CITY OF ALBUQUERQUE
PLANNING DEPARTMENT
December 21, 2011
DRB Comments

PROJECT # 1009081

RE: Block 4, Mesa Grande Addition

8. **Project# 1009081**
11DRB-70349 SKETCH PLAT REVIEW
AND COMMENT
- INTEGRATED DESIGN & ARCHITECTURE agent(s) for DE ANZA DEVELOPER LLC / CITY OF ALBUQUERQUE request(s) the above action(s) for all or a portion of Lot(s) 1-17, Block(s) 004, **MESA GRAND ADDITION**, zoned CCR-2, located on CENTRAL AVE BETWEEN WASHINGTON AND GRACELAND containing approximately 2.08 acre(s). (K-17) **THE SKETCH PLAT WAS REVIEWED AND COMMENTS WERE PROVIDED.**

DE ANZA COURTYARD HOMES - SKETCH PLAT

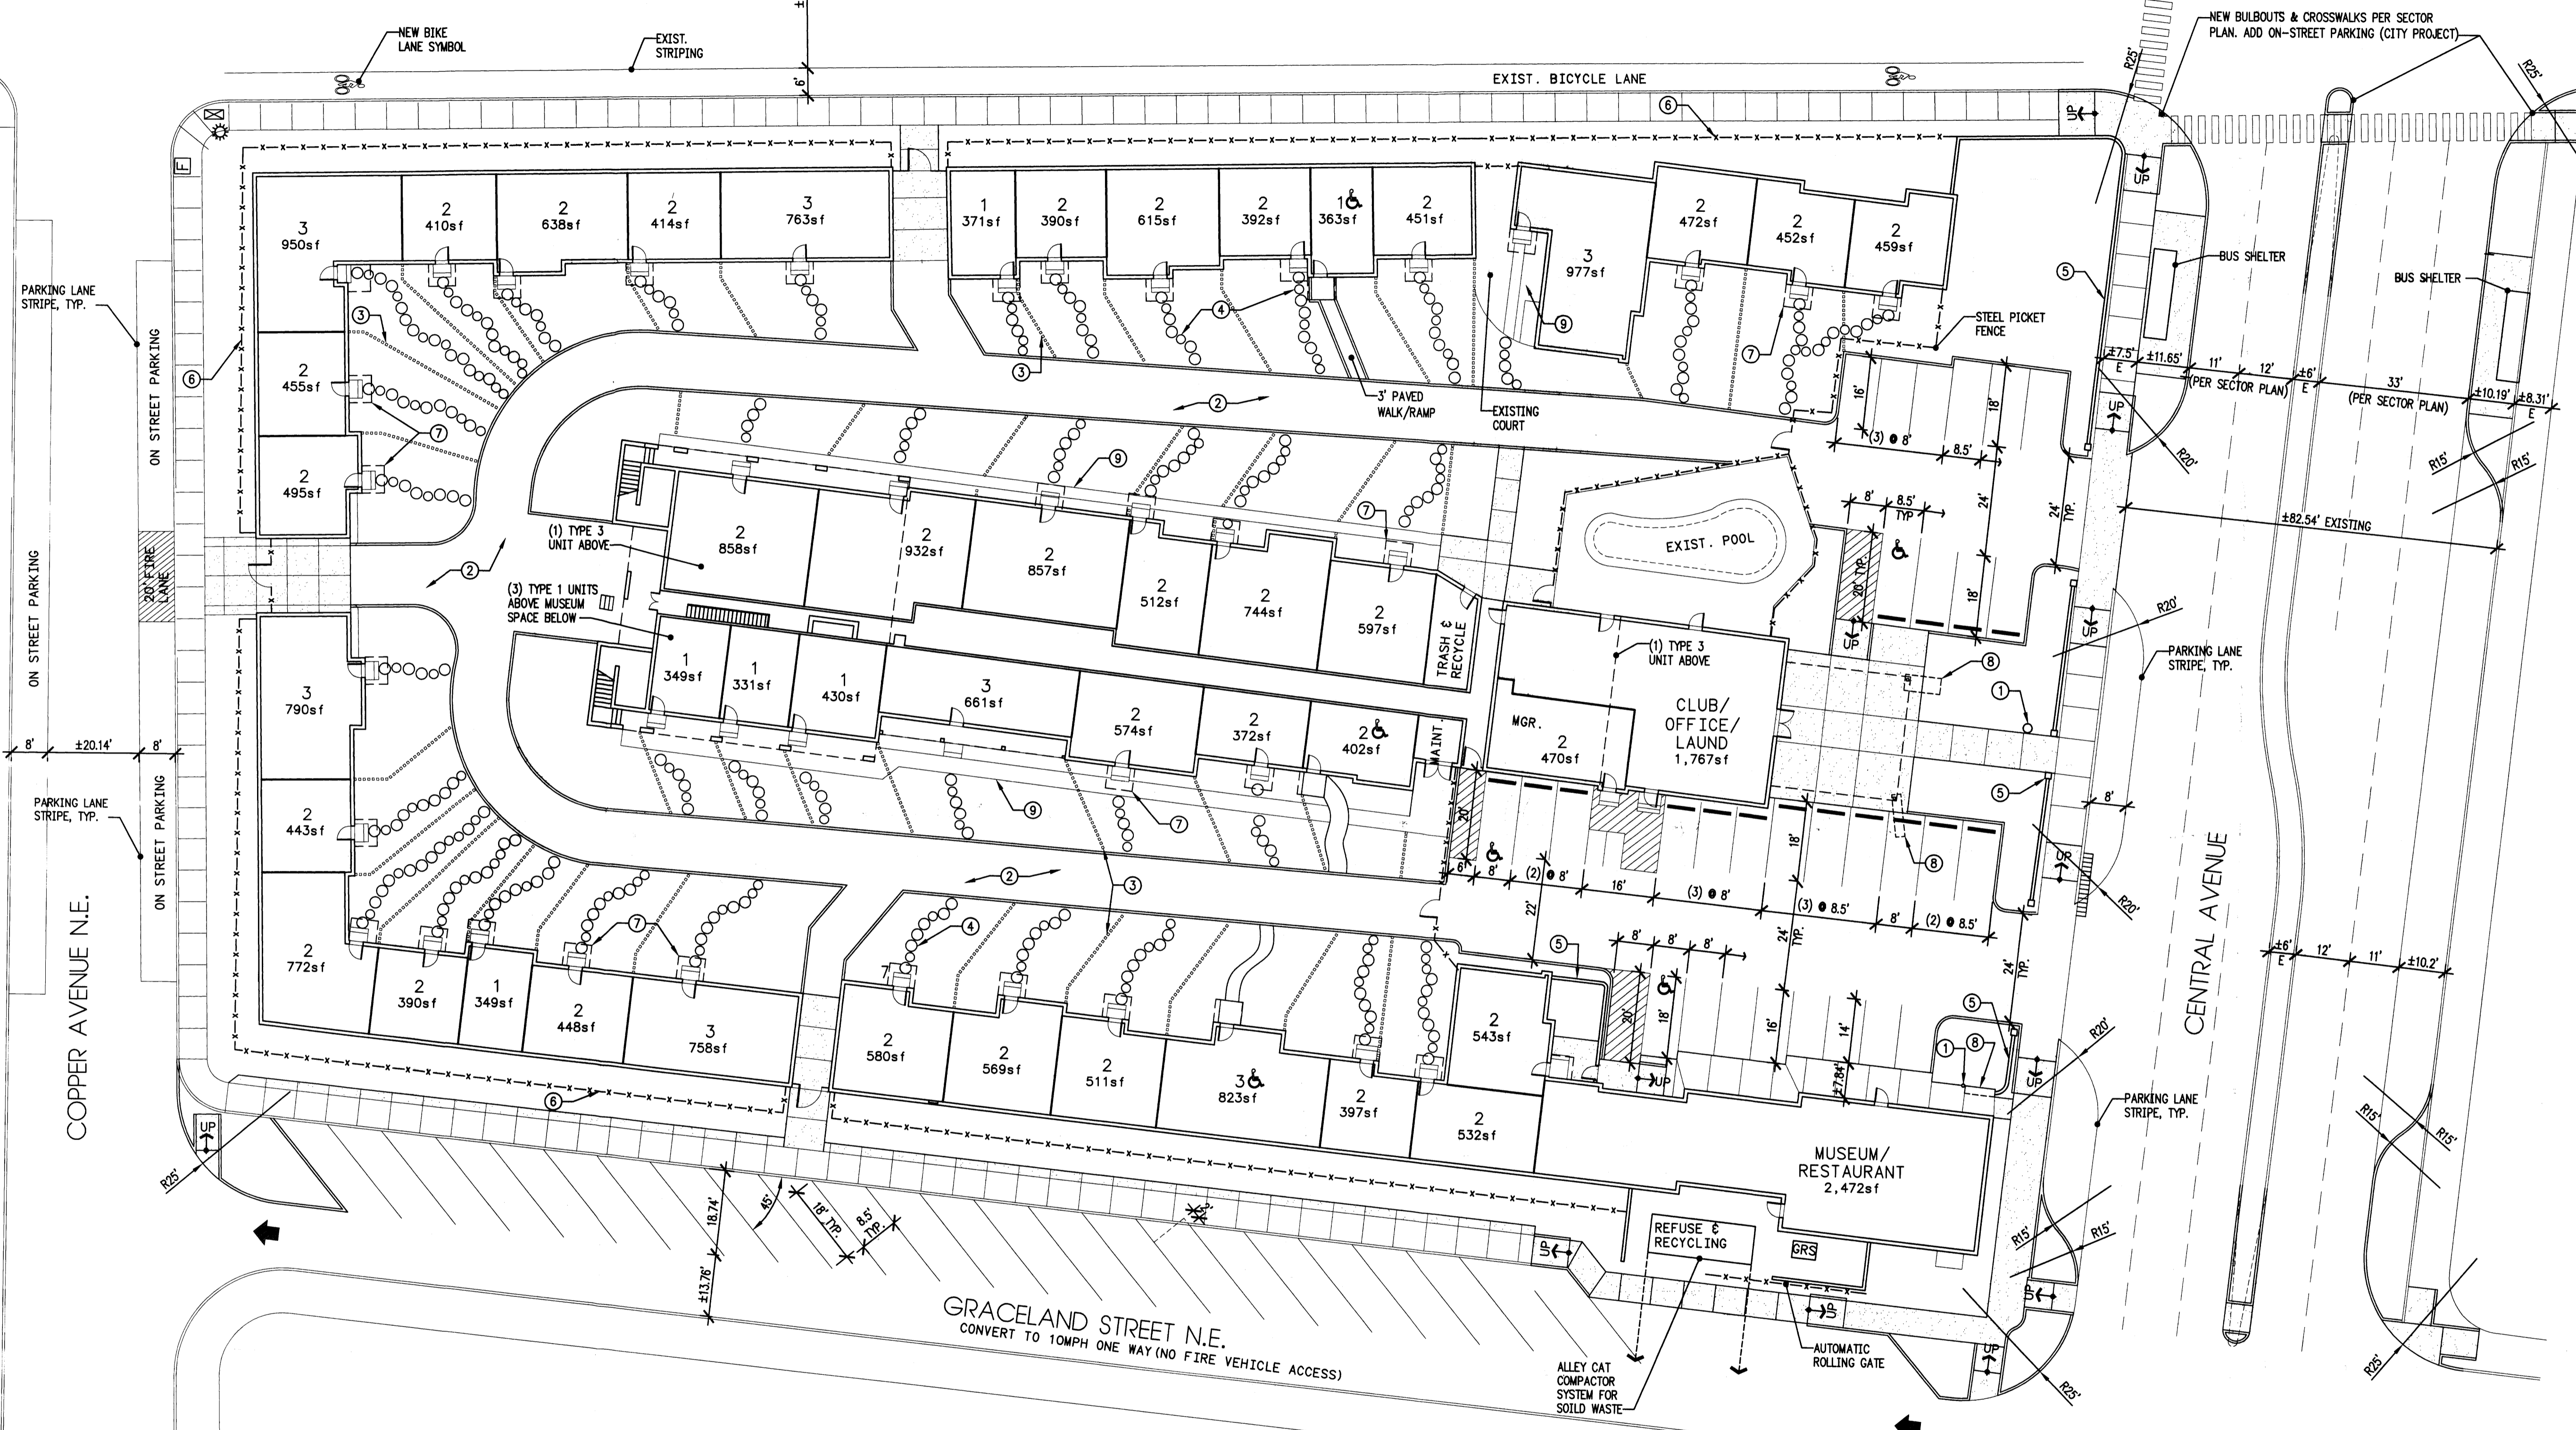
Refer to comments from Transportation Development regarding one way designation for Graceland. Vacation of right of way would be needed for the proposed configuration, particularly for refuse and enclosure in the southwest corner of the site. Vacation of the alley within the block will be required.
